## ULAN WEST MODIFICATION

Response To Submissions

August 2015

Prepared by  
**Umwelt (Australia) Pty Limited**

Figure 6: Contours of subsidence predicted for the proposed Ulan West modification area.

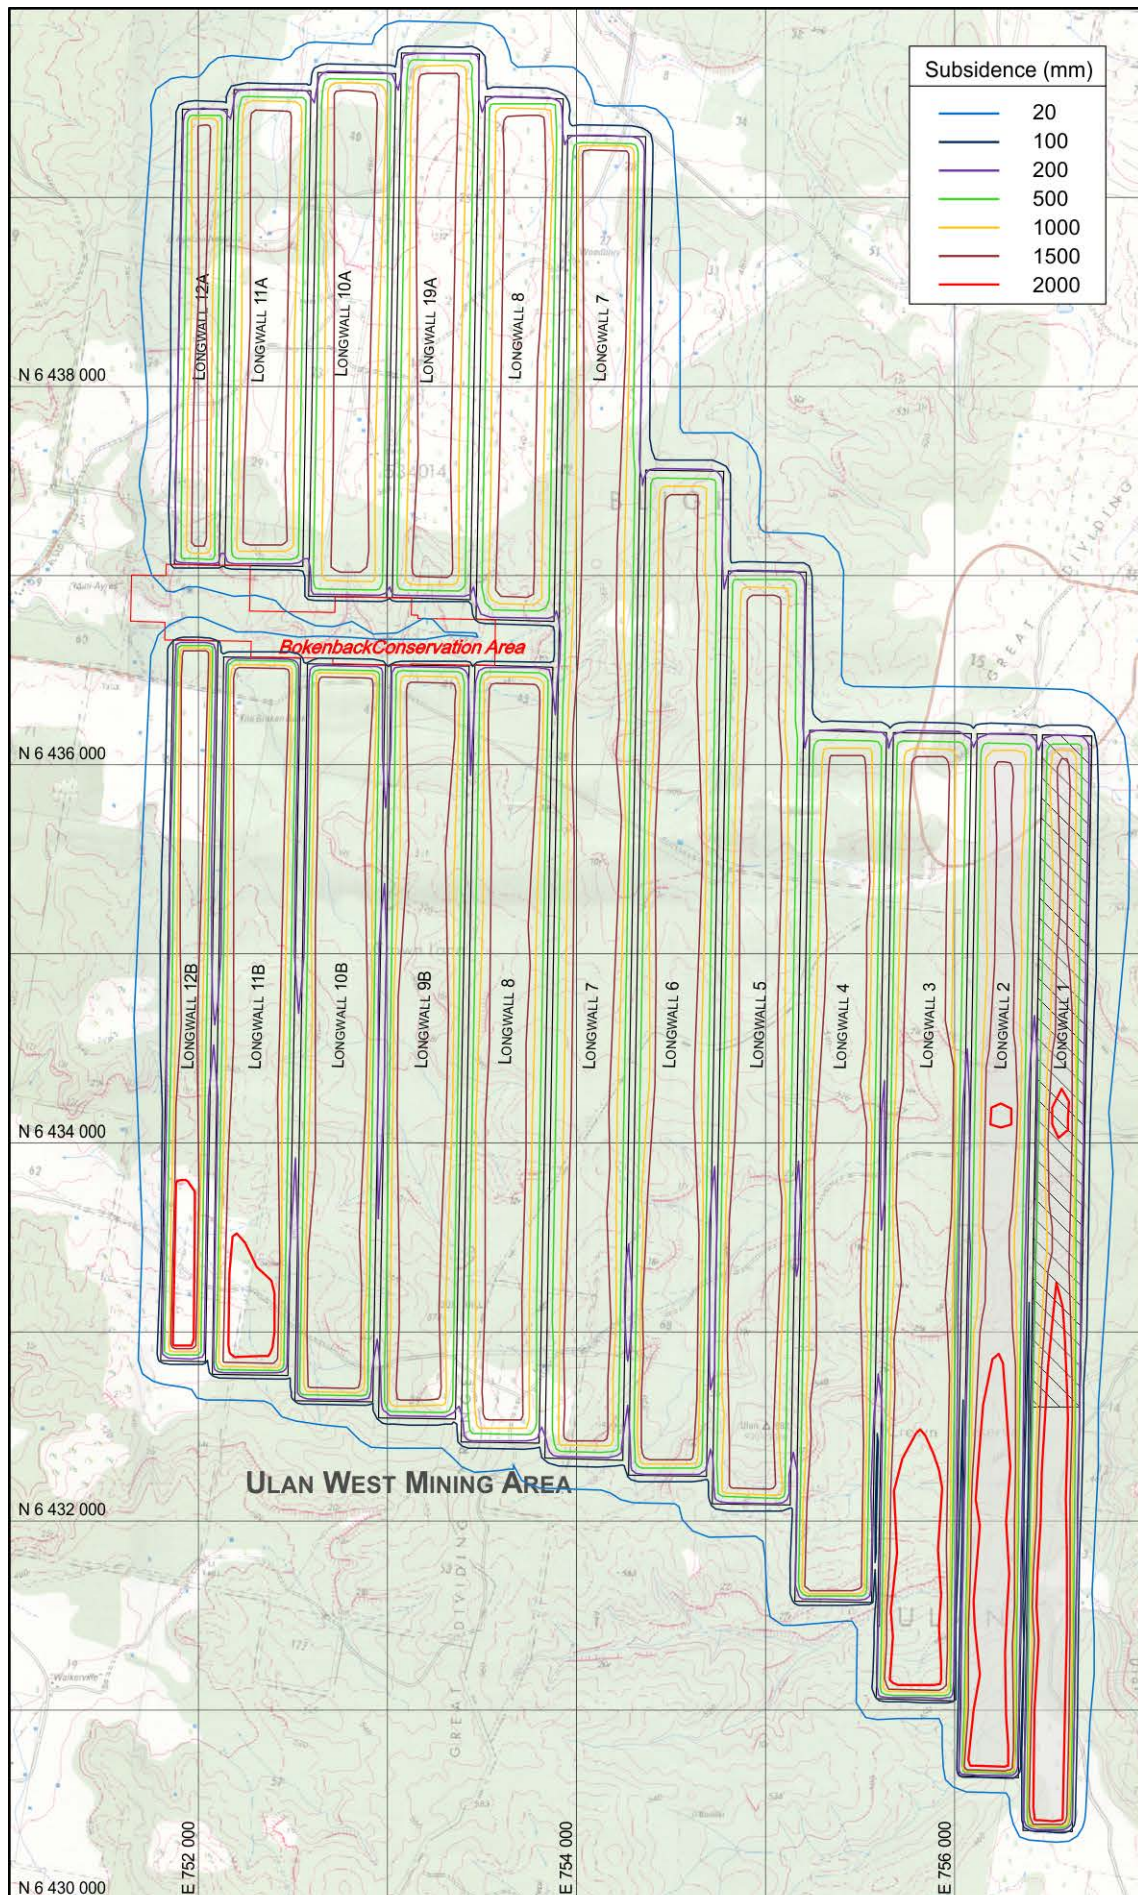
**OEH is concerned that the environmental assessment (EA) makes statements that broadly compare the impacts of the proposed modification with the currently approved project without clearly substantiating claims made.**

A detailed subsidence assessment was prepared by Strata Control Technologies (SCT) for the proposed modification and is contained within Appendix 2 of the EA and a summary provided in Section 5.2 of the EA main text.

As outlined in Section 3.3 of the Subsidence Assessment (Appendix 2 of the EA), the approach to estimating subsidence used in the SCT assessment is based on a review of previous experience over 33 previous longwall panels at Ulan No. 3 mine and estimating the maximum likely subsidence based on this data. This method is an empirical approach suitable for providing an upper limit based on experience to date. Actual subsidence and subsidence parameters are expected to be generally less and in most cases significantly less than the upper limit values provided by an empirical approach, as has been experienced previously at the Ulan Coal Complex. The upper limit estimate of subsidence movements is considered appropriate for assessment purposes.

Recent experience in Ulan West LW1 has indicated that subsidence behaviour for mining to date in the Ulan West area is as expected (SCT 2015a). The measured values are generally less than predicted and of the expected form. Maximum subsidence to date has been 1.2 metres (SCT 2015a) and within the 0.9 to 1.5 metre range predicted in the Subsidence Assessment for the EA.

The approach taken in the SCT (2015) assessment for the EA has been to provide conservative estimates of subsidence, recognising that in the particular circumstances at Ulan West Mine, none of the impacts are likely to be particularly sensitive to the specific magnitude of subsidence, but rather to the general nature of the subsidence expected. Further refinement is expected to be possible as the subsidence database for shallower areas and observations of subsidence behaviour across multiple depth ranges increases with further high quality subsidence monitoring.

Subsidence for the modified Ulan West mining area is expected to be generally consistent with subsidence experienced in the previously mined longwall panels within Ulan No.3 subject to the prediction estimates, particularly vertical subsidence and angle of draw as discussed below. The key subsidence impact parameter prediction results are outlined in **Table 1**.

The maximum vertical subsidence prediction has increased from the UCCO Project assessment. The magnitude of subsidence is greater in the lower depth of cover areas associated with the proposed modified Ulan West mining area and the nominal mining height used for assessment purposes has increased from 2.9 metres in the UCCO Project assessment to 3.2 metres in the assessment associated with the proposed modification, due to the estimated likely height feasible to extract.

Figure 6 of the Subsidence Assessment (Appendix 2 of the EA) demonstrates the predicted subsidence for the modified Ulan West mining area.
